Item No.	Report of the Head of Development Management and Building Control		
Address:	63 HIGH STREET RUISLIP		
Development:	Change of use of from Office/Storage (Class E) and internal alterations to provide 1 x studio, 1 x 1 bed and 1 x 2 bed residential units (Class C3) (revised description 14.08.24)		
LBH Ref Nos:	3317/APP/2024/2048		
Drawing Nos:	63highstreet/2024/01A 63highstreet/2024/04B 63highstreet/2024/05B 63highstreet/2024/06A 63highstreet/2024/07A 63highstreet/2024/01 63highstreet/2024/02 63highstreet/2024/03		
Date Plans received:	30-07-24	Date(s) of Amendments(s):	16-10-24
Date Application valid	30-07-24		06-08-24
			06-08-24

Planning permission is sought for the change of use of from Office/Storage (Class E) and internal alterations to provide 1 x studio, 1 x 1 bed and 1 x 2 bed residential units (Class C3).

<u>Site Address:</u>	<u>Drawing Content:</u>	<u>Drawings No:</u>	<u>Date Drawn:</u>	Planning Issue						
63 High Street Ruislip HA4 8JB	Existing First Floor Plan	63highstreet/2024/01A	22nd July 2024	7						
1	2	<u>Drawings Scale:</u>	<u>Drawn By:</u>	<u>Revision:</u>						
		1:50	KG						8

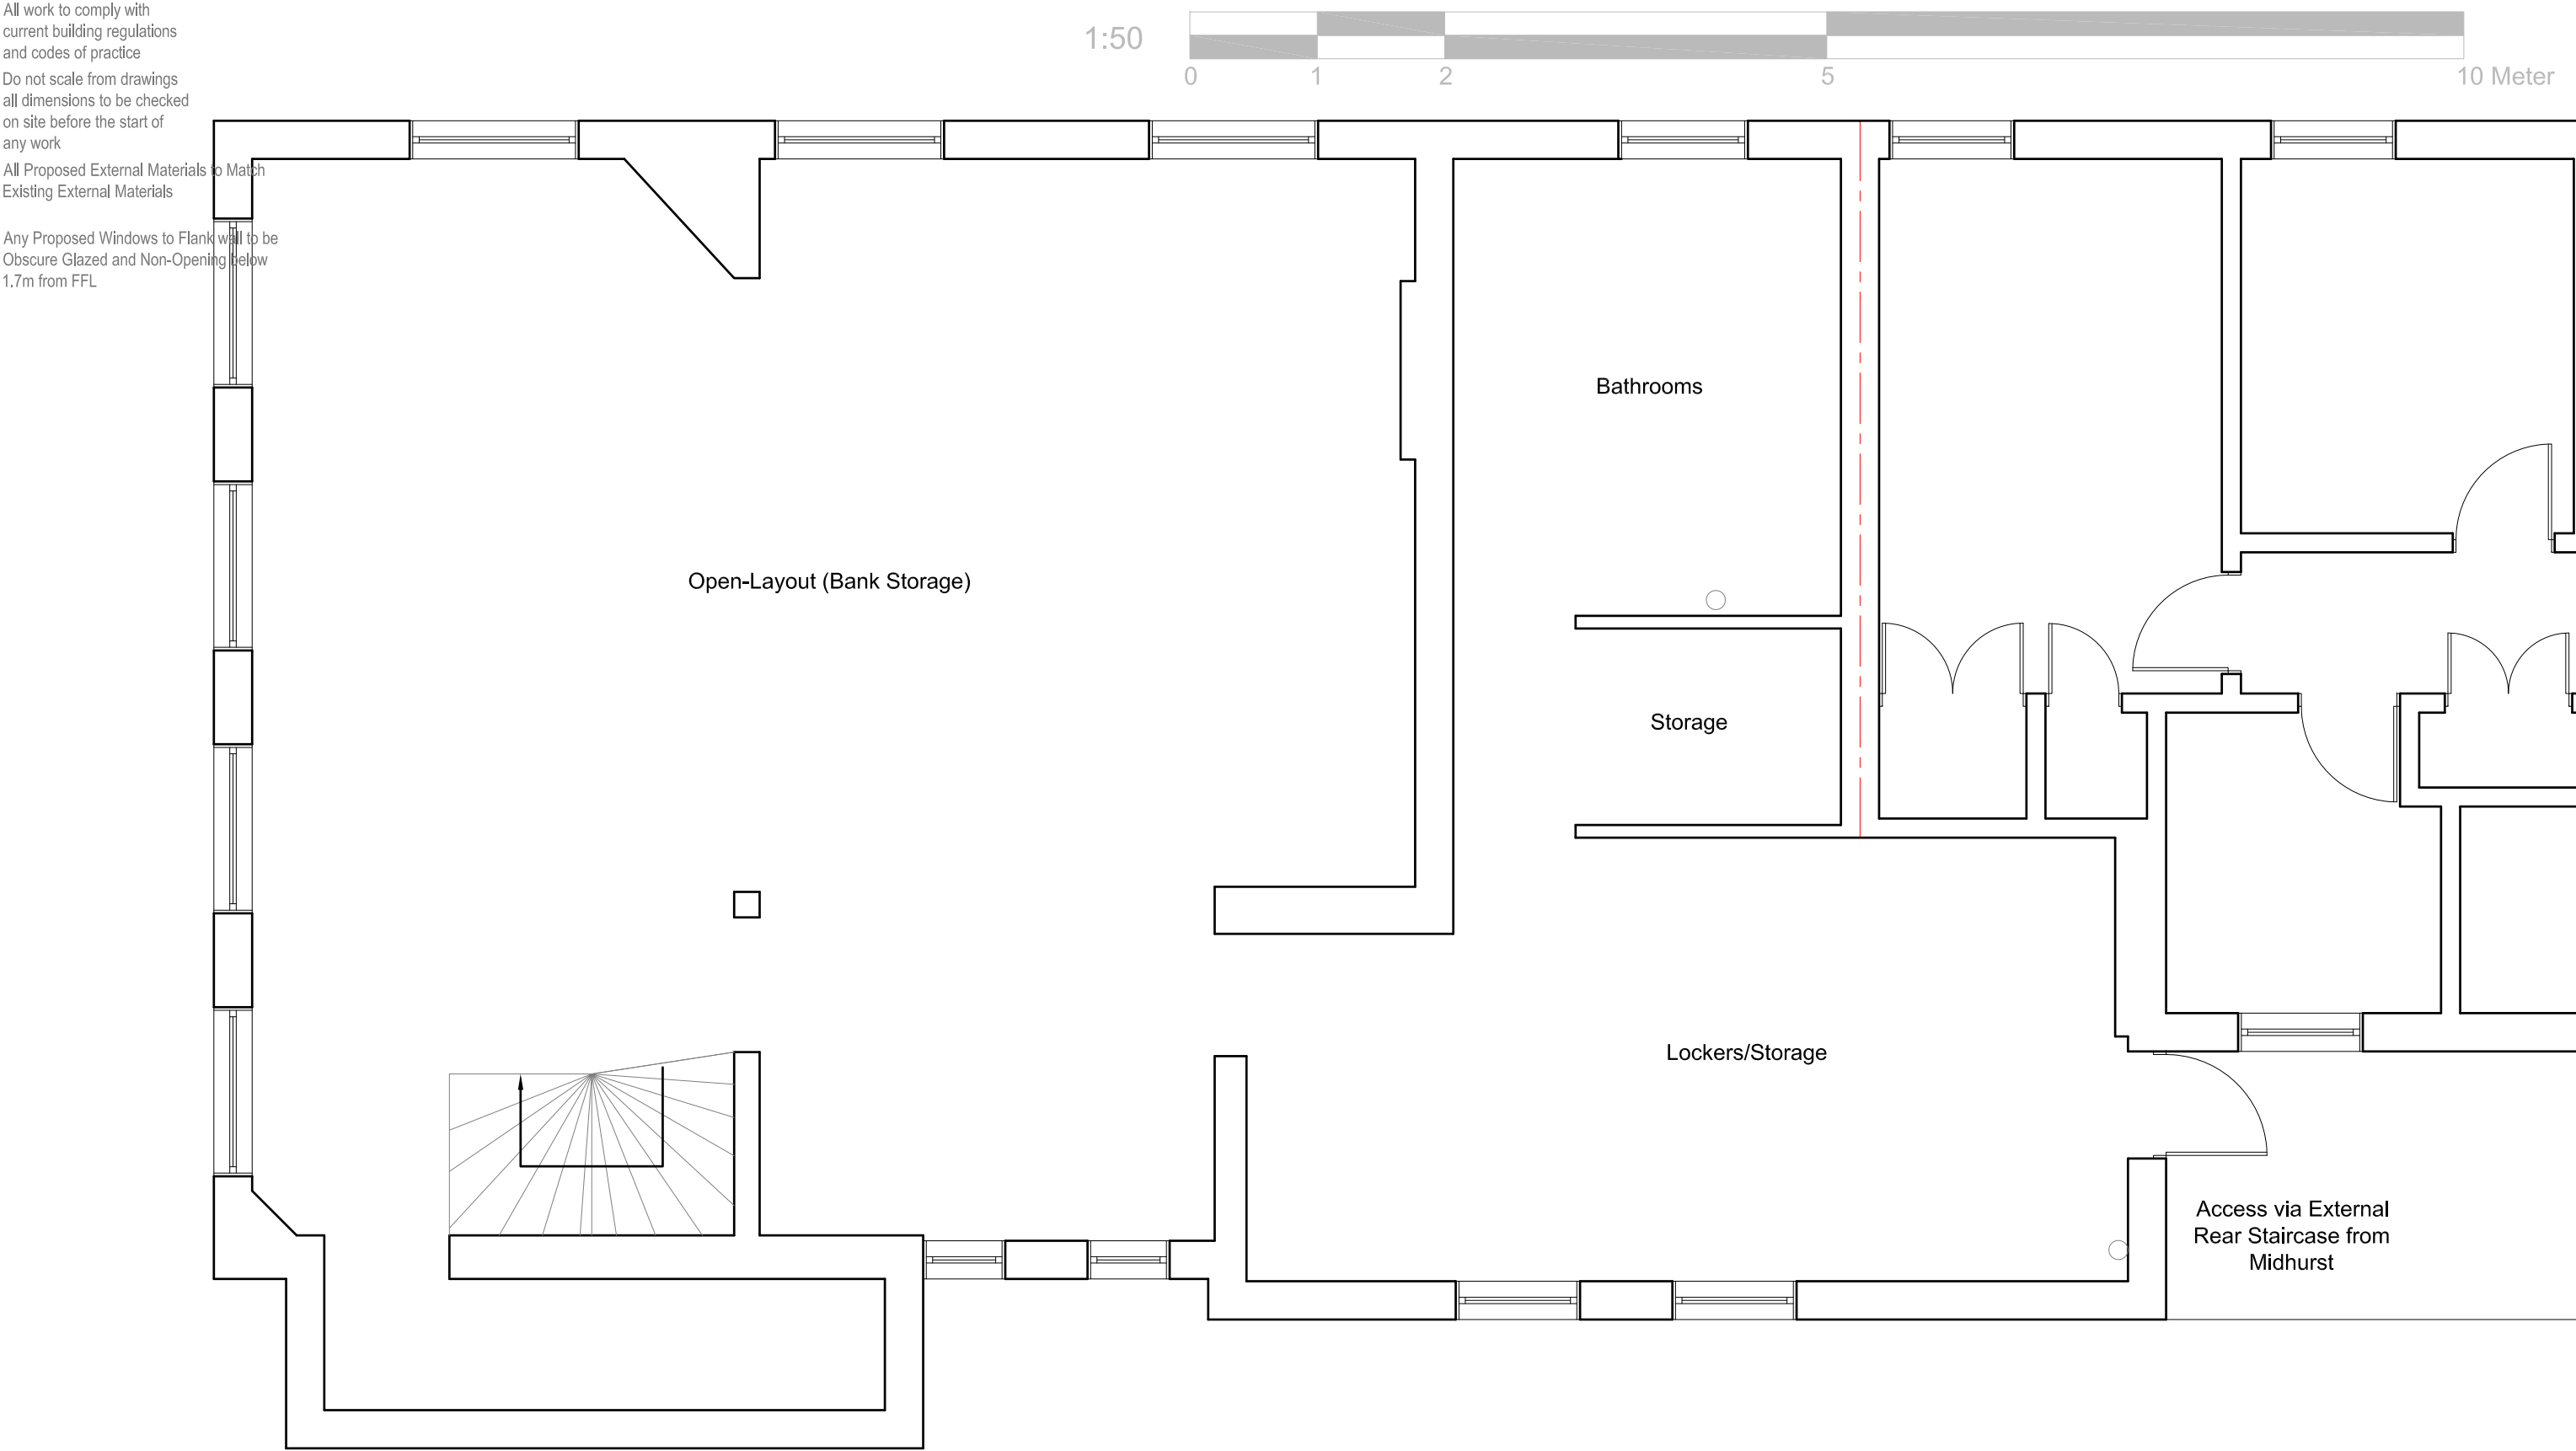
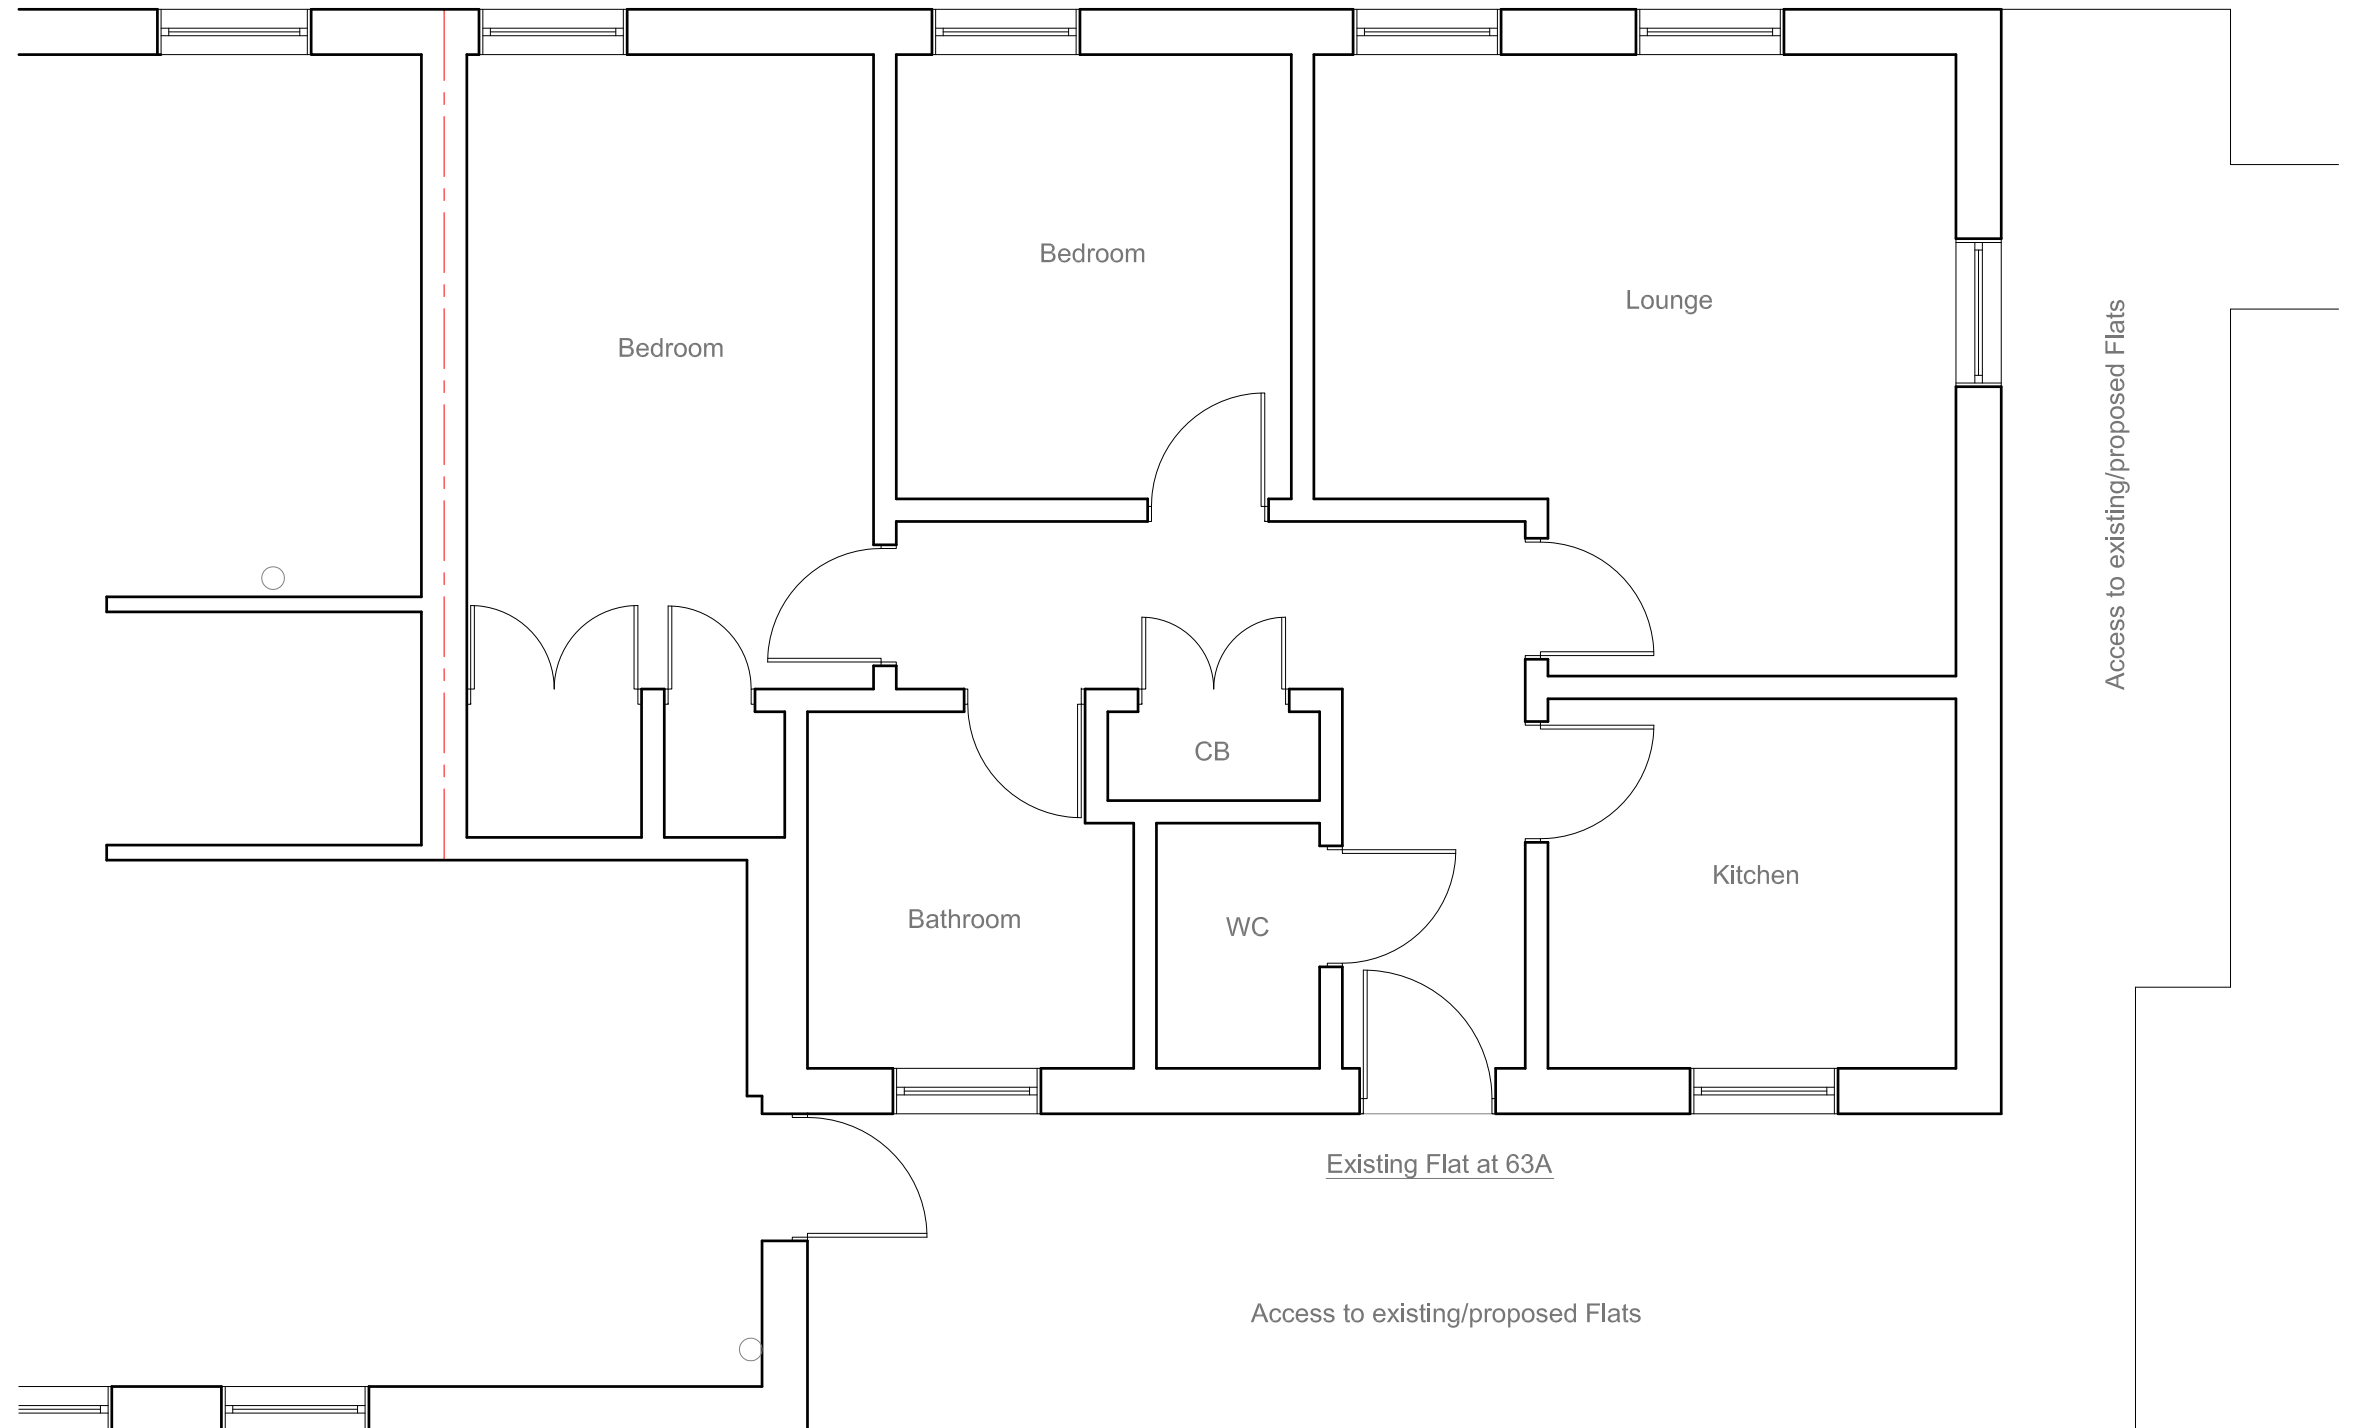
- Concerns regarding building works including noise, traffic and litter
- Neighbouring dwelling omitted from floor plans
- Concerns regarding internal noise on adjoining walls
- Loss of privacy (due to access walk way)

Revised plans were provided demonstrating No.63A to ensure the assessment was thorough. The concerns are discussed in the neighbouring amenity section below.

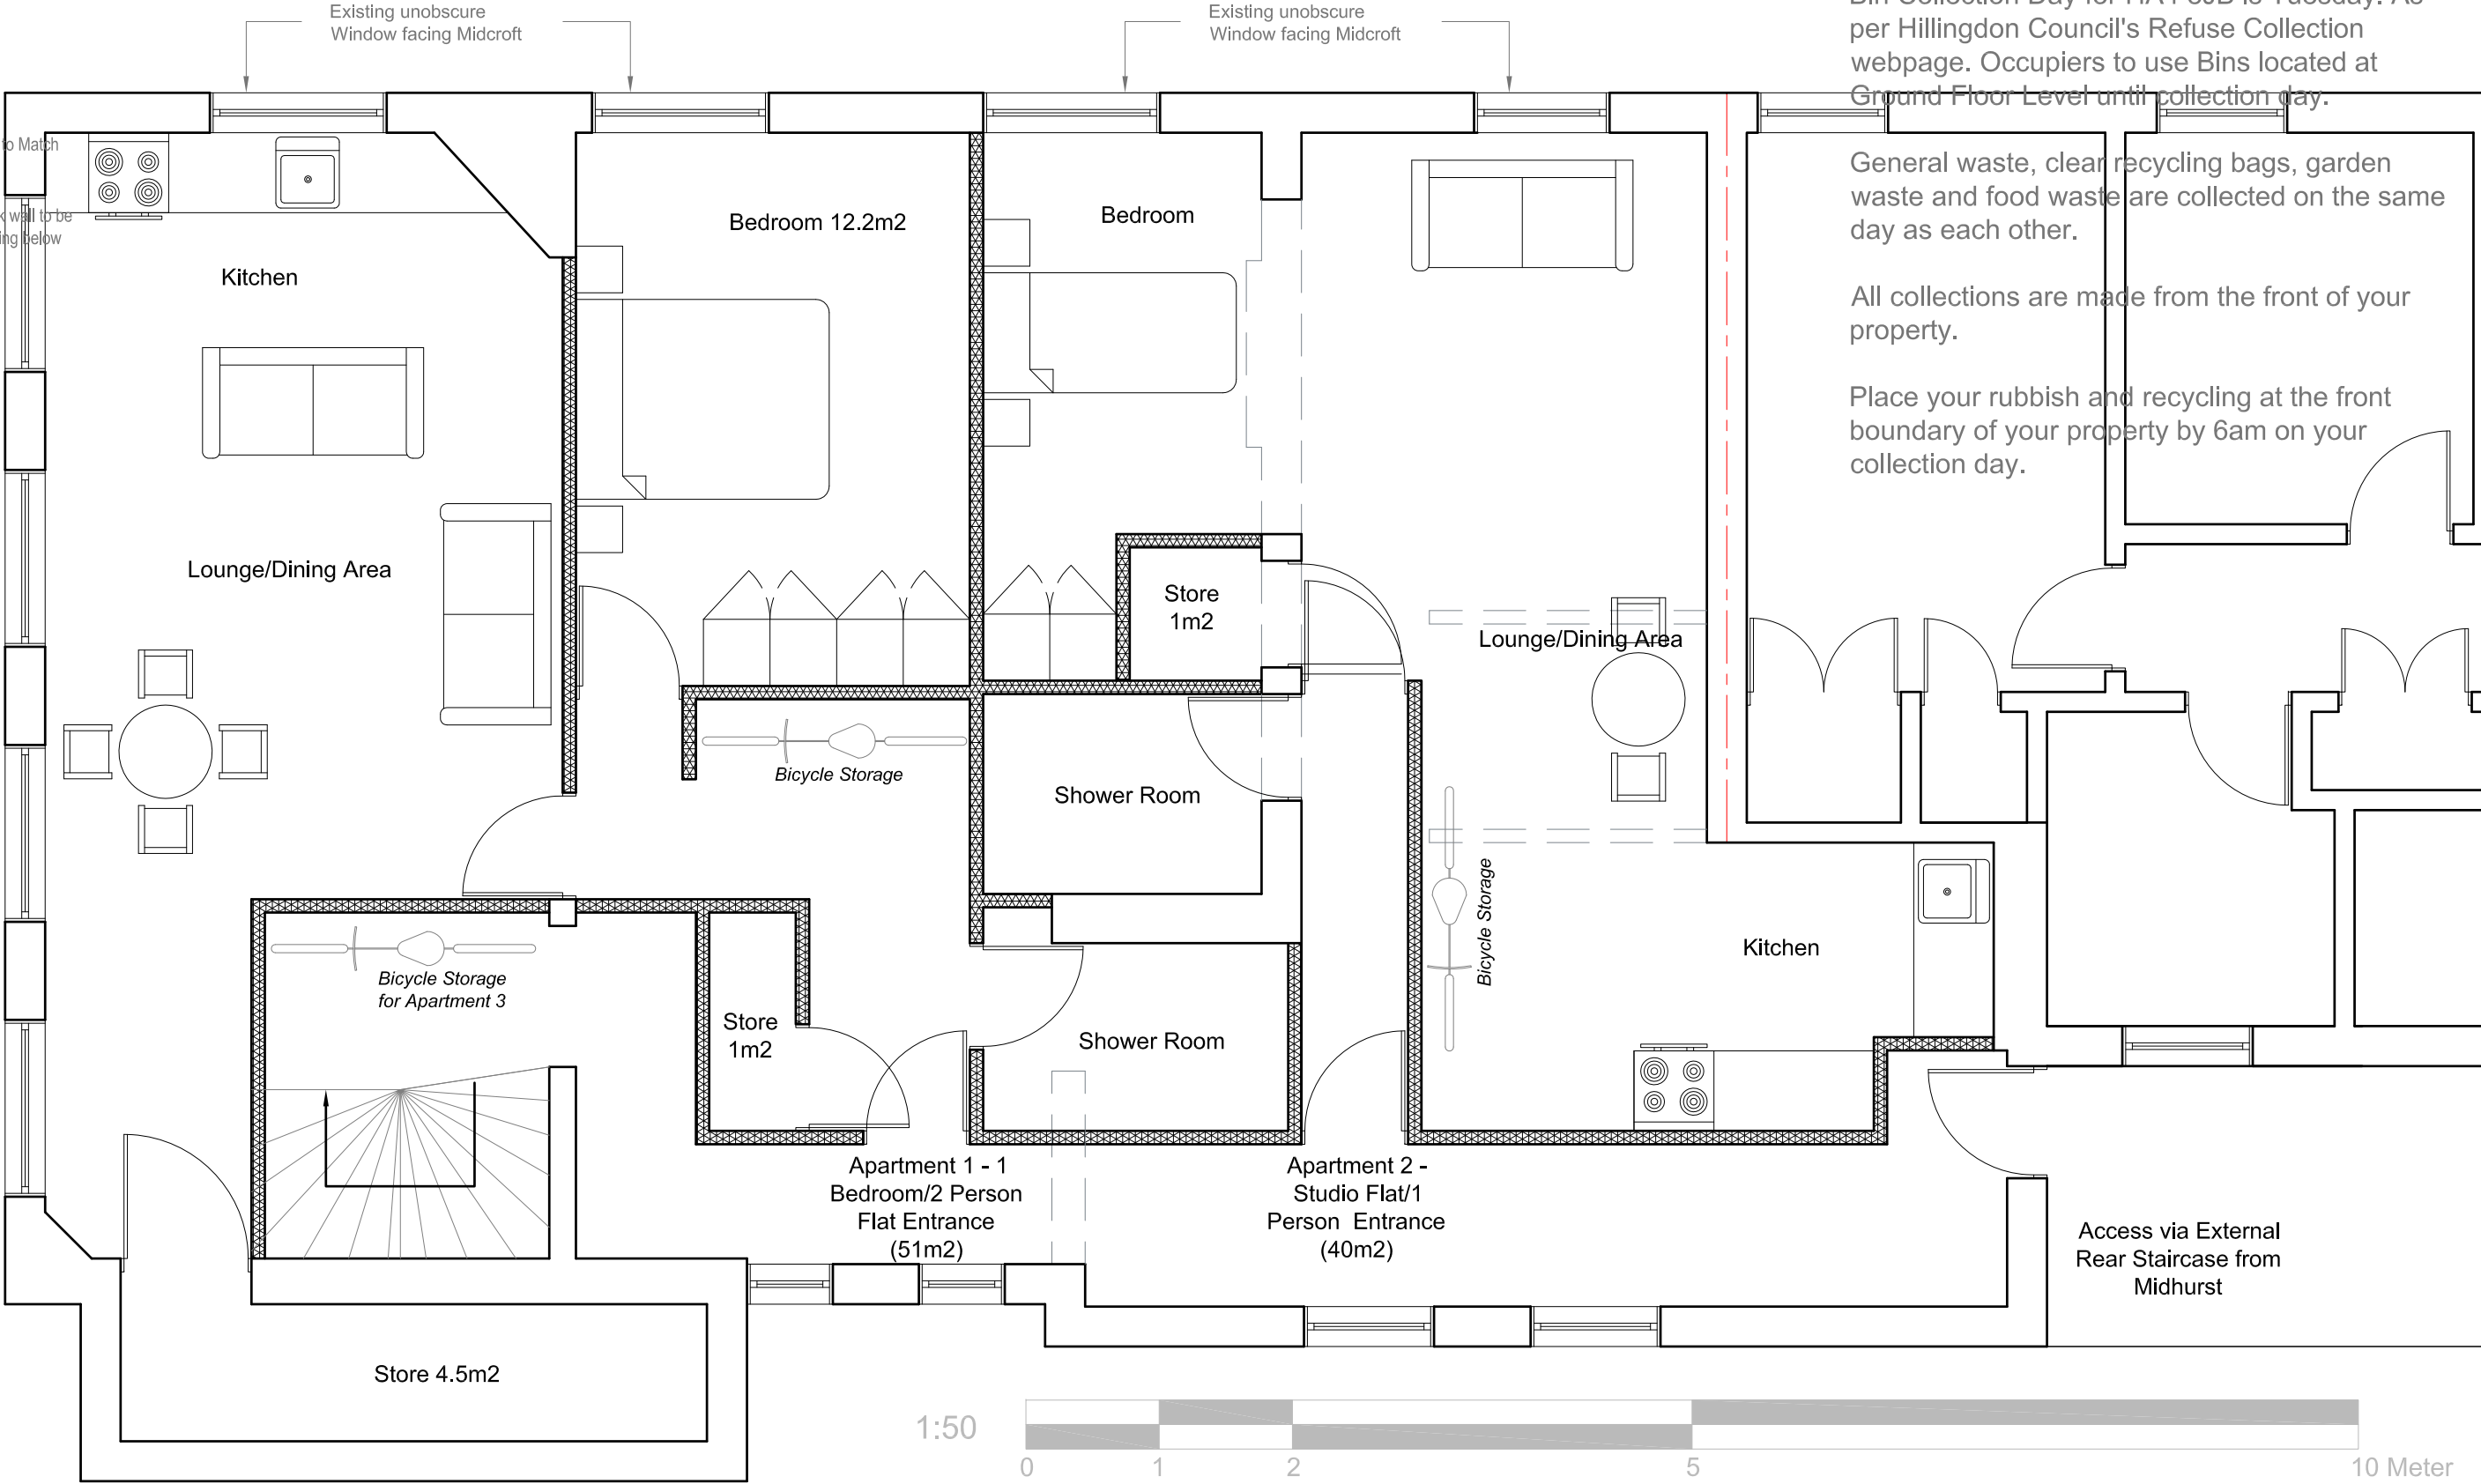
In terms of cycle parking there would be a requirement to provide a total of 3 secure and accessible spaces for the 3 units. It is recommended that a suitable space saving cycle wall rack located internally within the flat itself is installed thereby allowing choice and flexibility in the type of cycle owned. The plans have been revised to show this detail.

In the case of waste management, collection distances between a designated bin store and a refuse vehicle should not exceed 10m in order to accord with the council's waste collection standard with carrying distances from each residential unit not exceeding a distance of 30m to the store.

The plan has been revised to show this detail.
